PLANNING APPLICATION: AW/230/14/T

ADDRESS: Sea Mist 15 Waters Edge Aldwick PO21 4AW

BRIEF DESCRIPTION: Reduce crowns of 3 No Monterey Cypress trees by 1 metre.

5 MONTEREY CYPRESS.

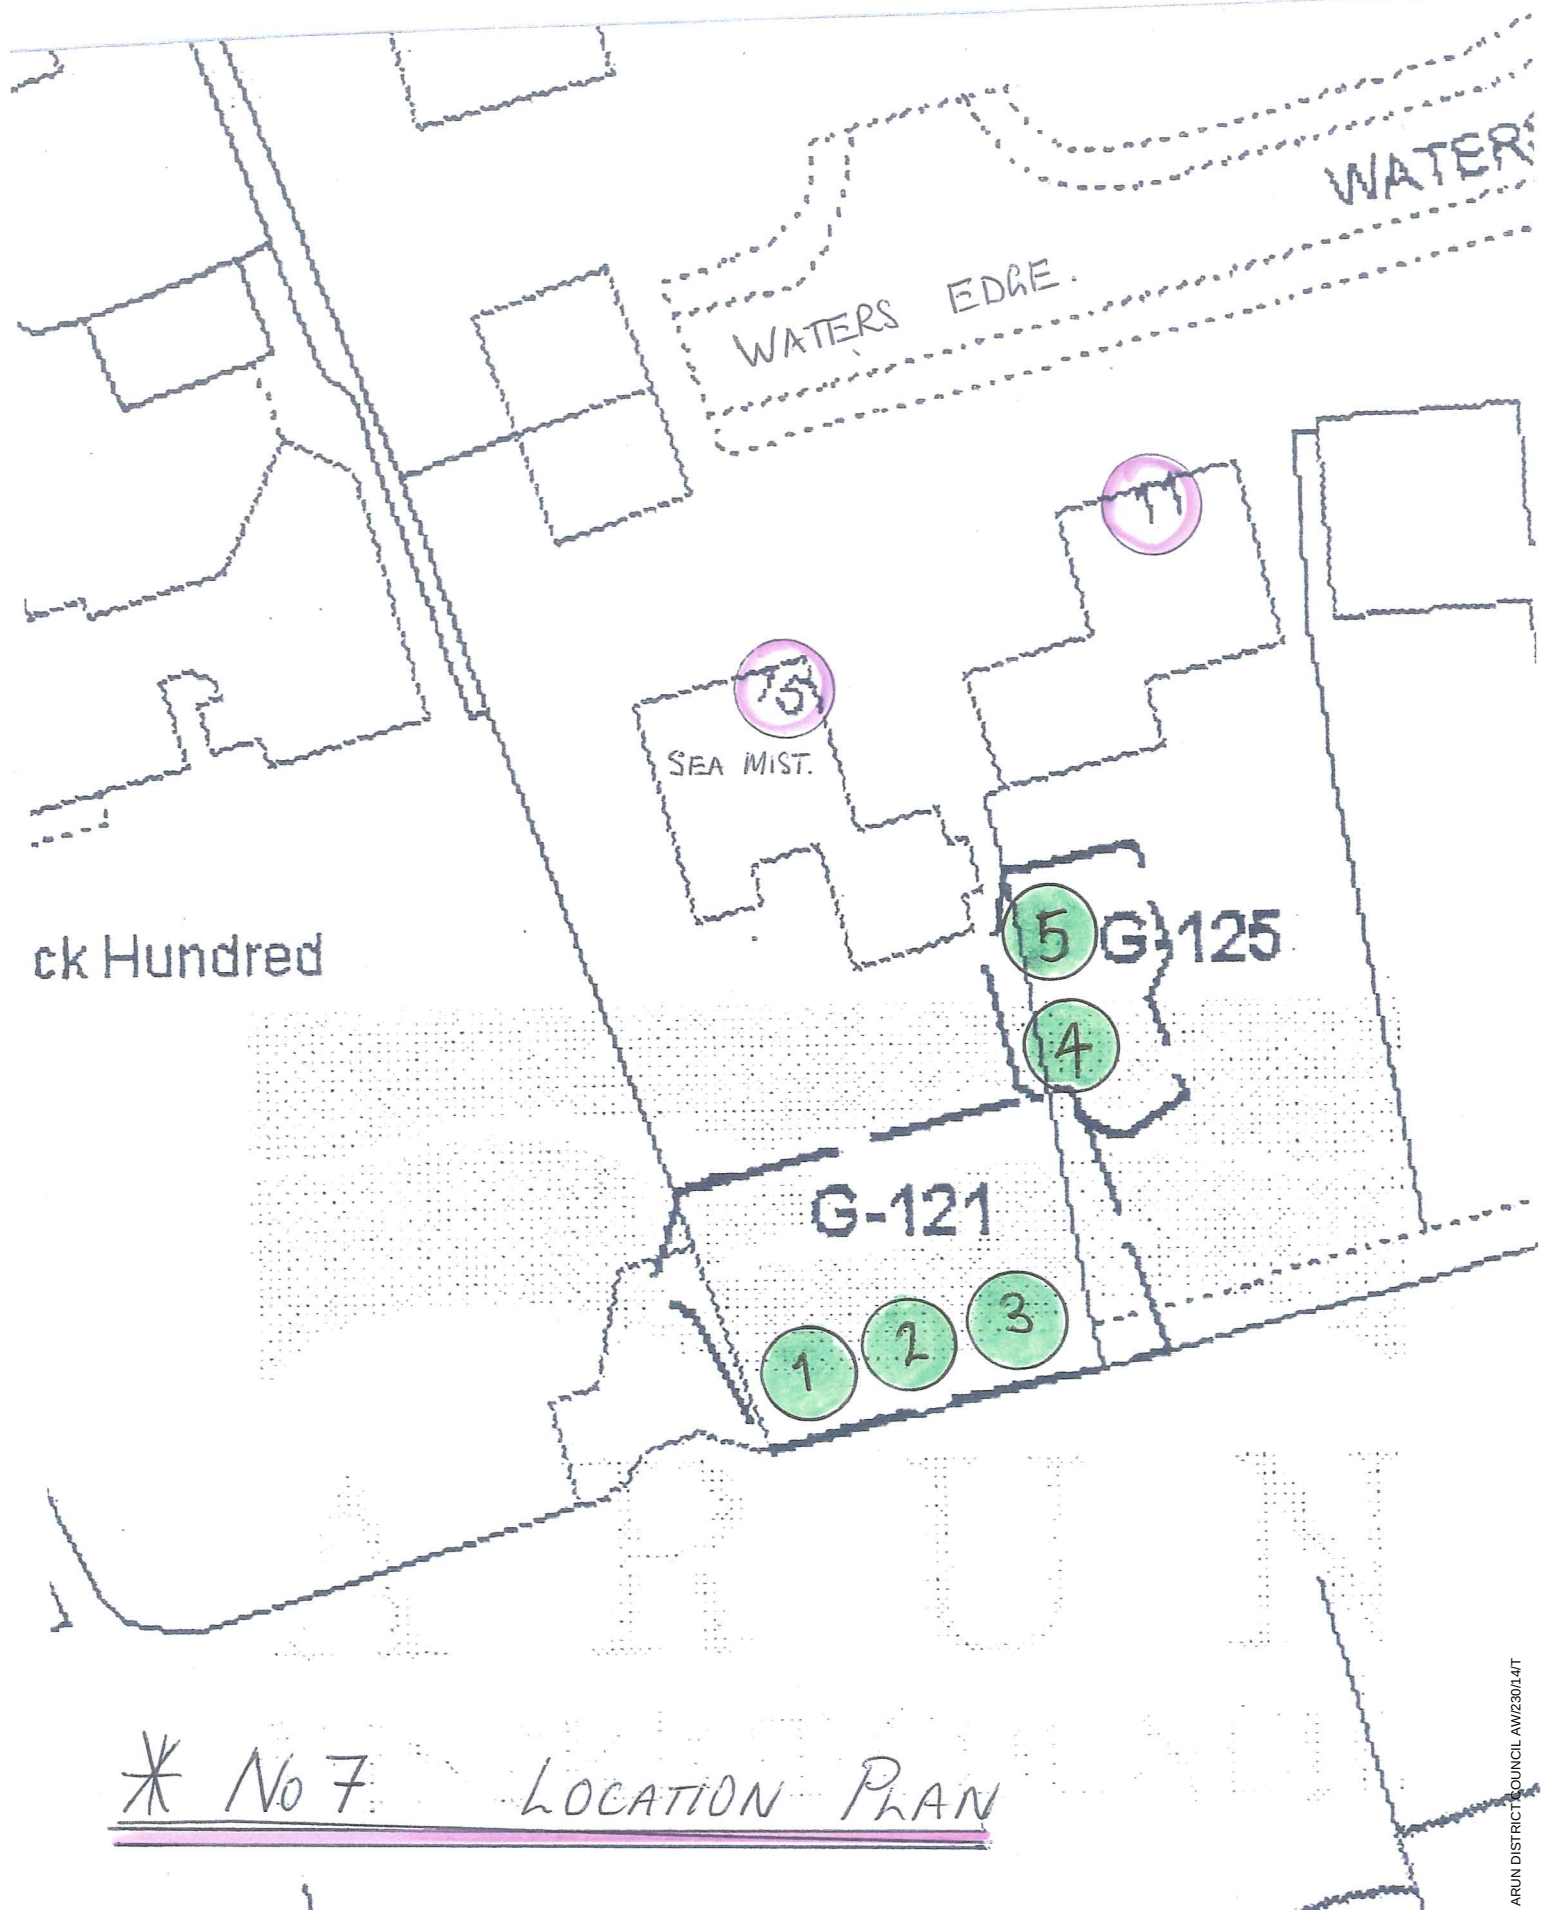
- The outlined trees in this application is situated at the rear boundary line, of the property Sea Mist, Aldwick.
- Unfortunately I could not obtain access into this site when I visited (as the occupants were out), so my survey was conducted by what I could see over the neighbour's fence.
- It is clear these trees have be systematically trained in top forming a screen at a set height to the end of the property
- The pruning operation that is proposed would be another 'cut' cycle on an established routine for these trees. Failure to adhere to this routine would see these 'hedge line' revert back to trees.

The Crown Reduction should not exceed the removal of single branch lengths which are greater than **1m** from the periphery of the original crown diameter. The branch removals should leave healthy substantial leaf bearing side branches. All side branches to be retained should be at least **1/3rd** in diameter of the removed branch. Pruning cuts must be flat and smooth, kept as small as possible by cutting at an optimum angle and should not exceed **100mm** in diameter.
